# Inspector's Report ABP 318505-23

Development	Proposed construction of a 110kV underground grid connection cable connecting the permitted Carrownagowan windfarm to the existing 110kV substation at Ardnacrusha.
Location	Within the townlands of Caherhurly, Killokennedy, Cloongaheen West, Leitrim, Castlebank, Ballykeelaun, County Clare.
Planning Authority	Clare County Council.
Applicant(s)	FuturEnergy Carrowngowan DAC.
Type of Application	Electricity Development - S.182(A)
Prescribed Bodies	Department of Housing, Local Government, and Heritage. Transport Infrastructure Ireland Clare County Council
Observer(s)	Brendan Sweeney Carrownagowan Concern Group Ute and Konrad Rumberger

## Section Through Permanent Reinstatement of Longitudinal Opening in Roadway

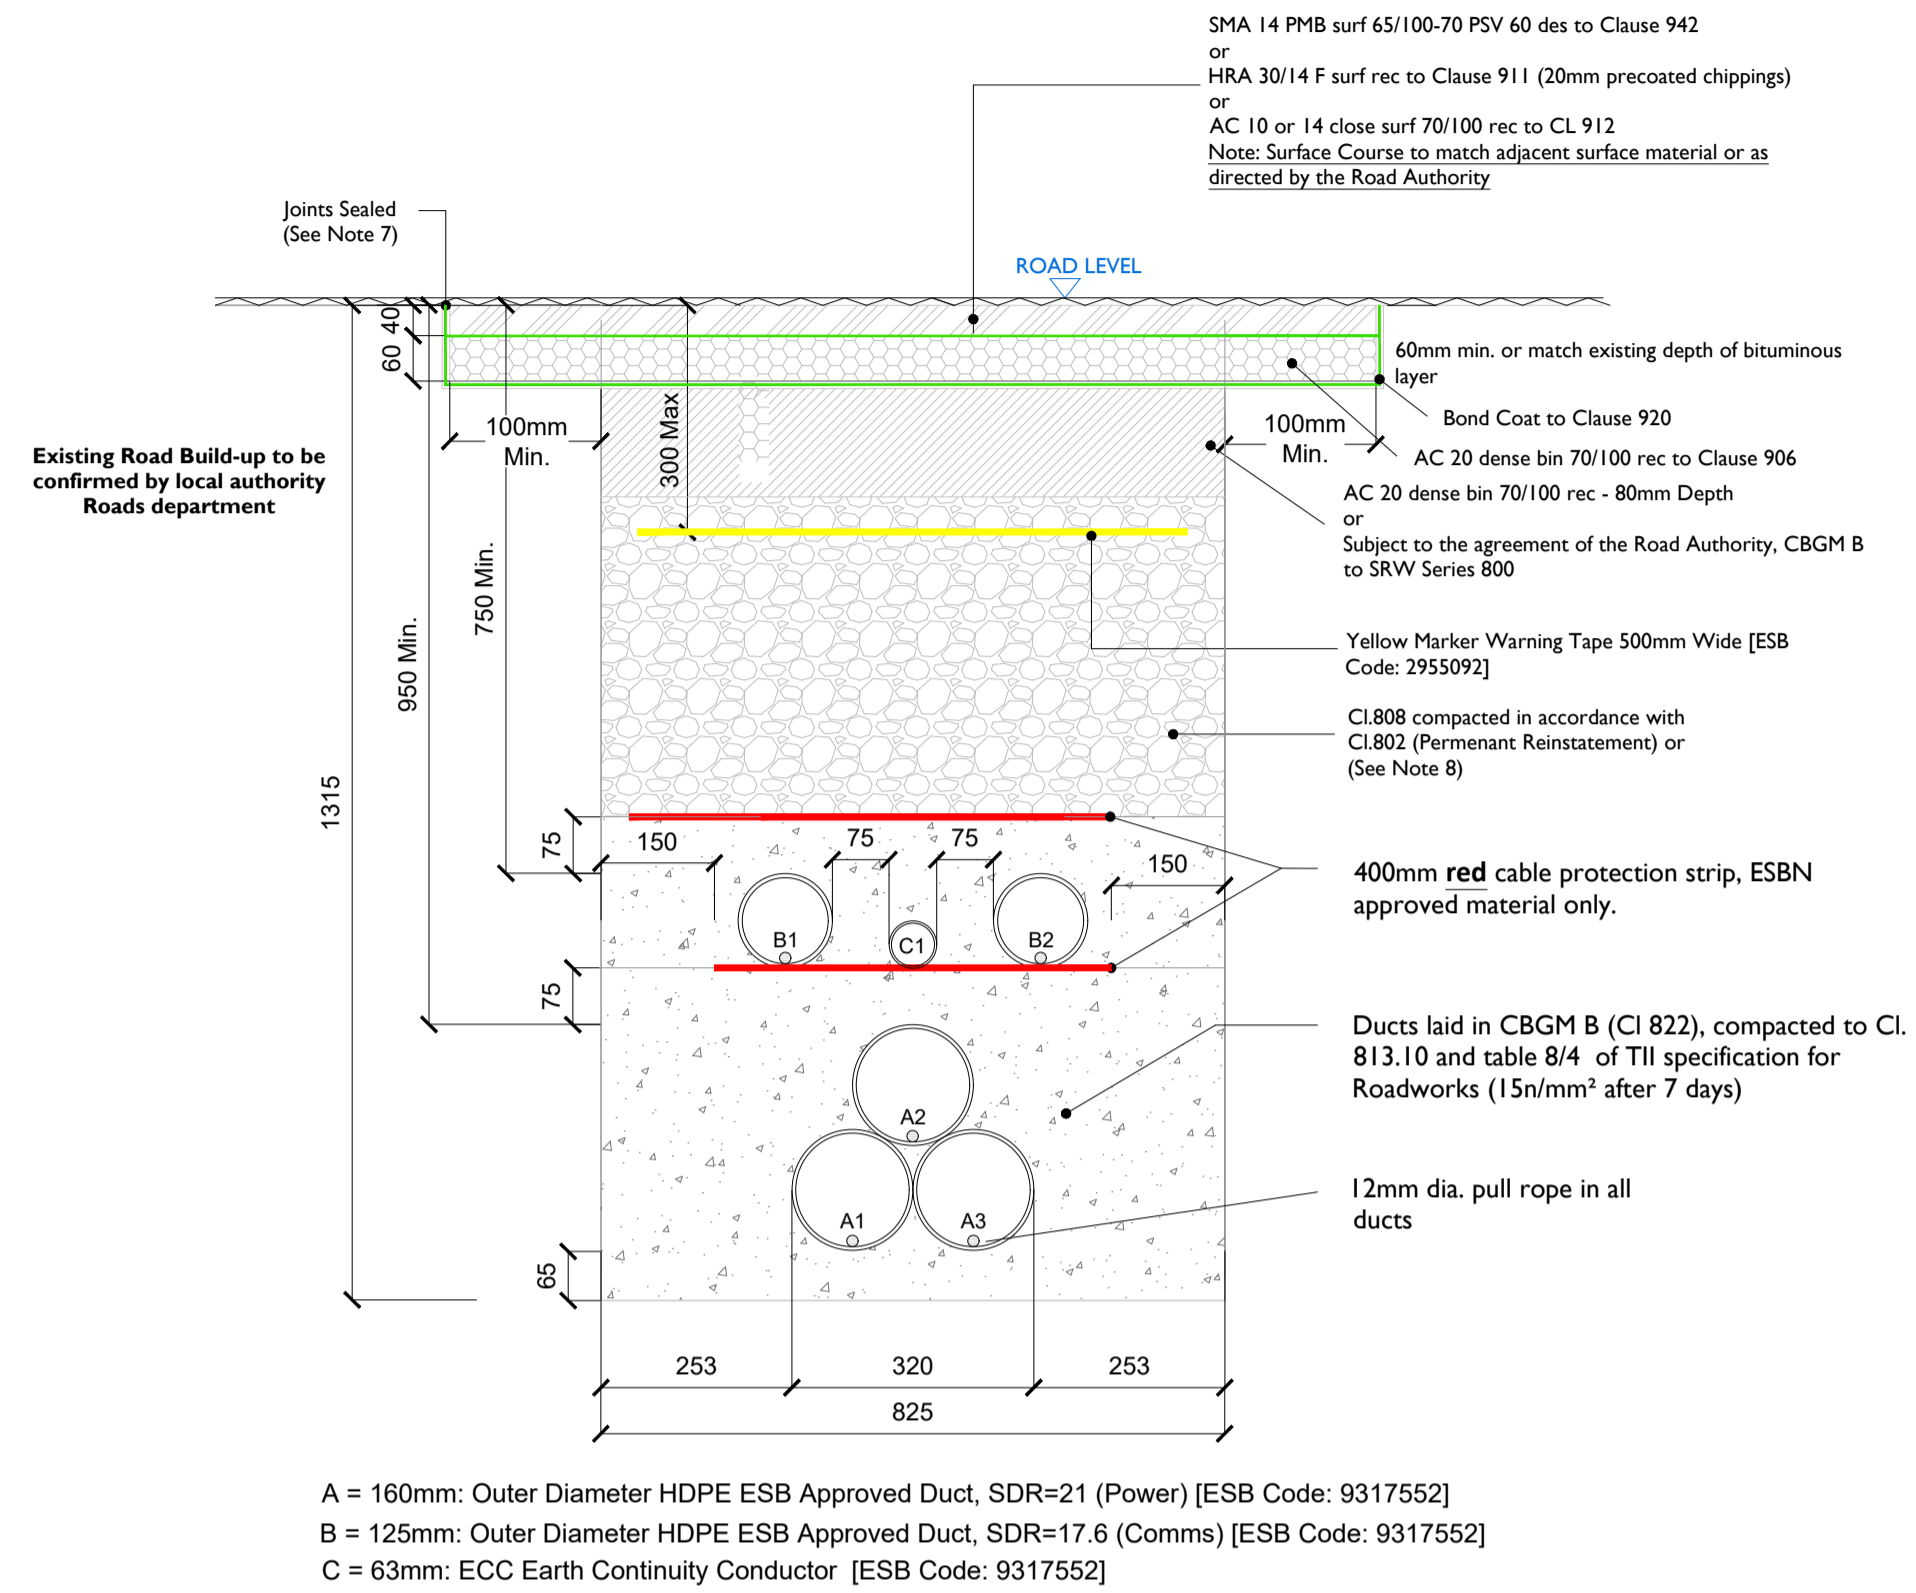
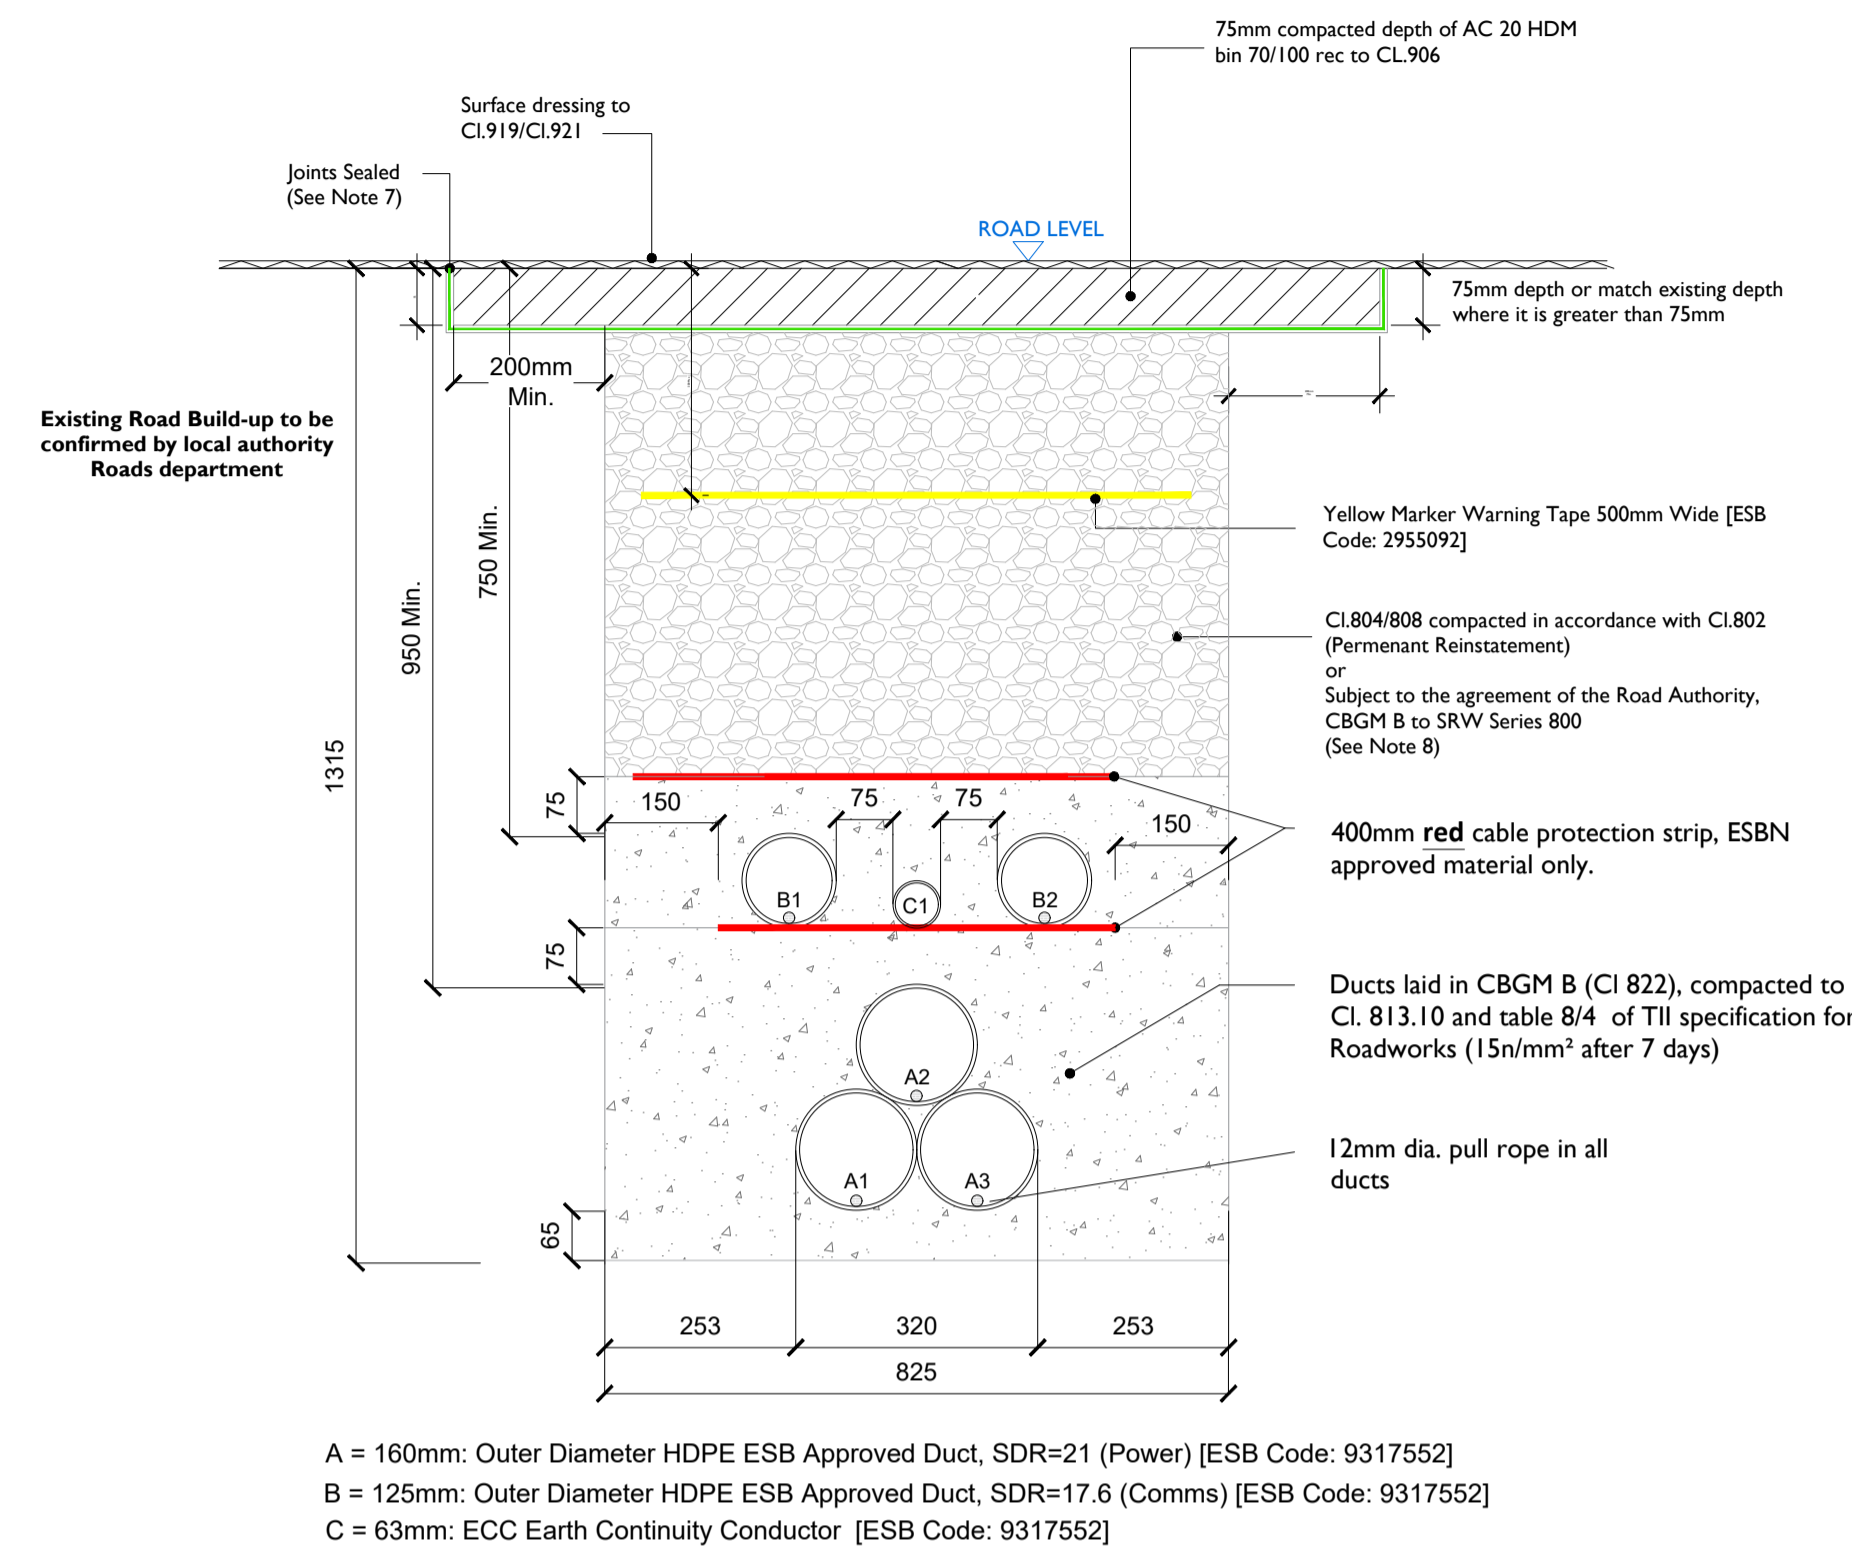
- The applicant should appoint a Community Relations Officer to communicate with the local community.
  - The proposed development should comply with Standard Drawing SD4 of the *Guidelines for Managing Openings in Public Roads*, specifically regarding the reinstatement of regional and local roads.
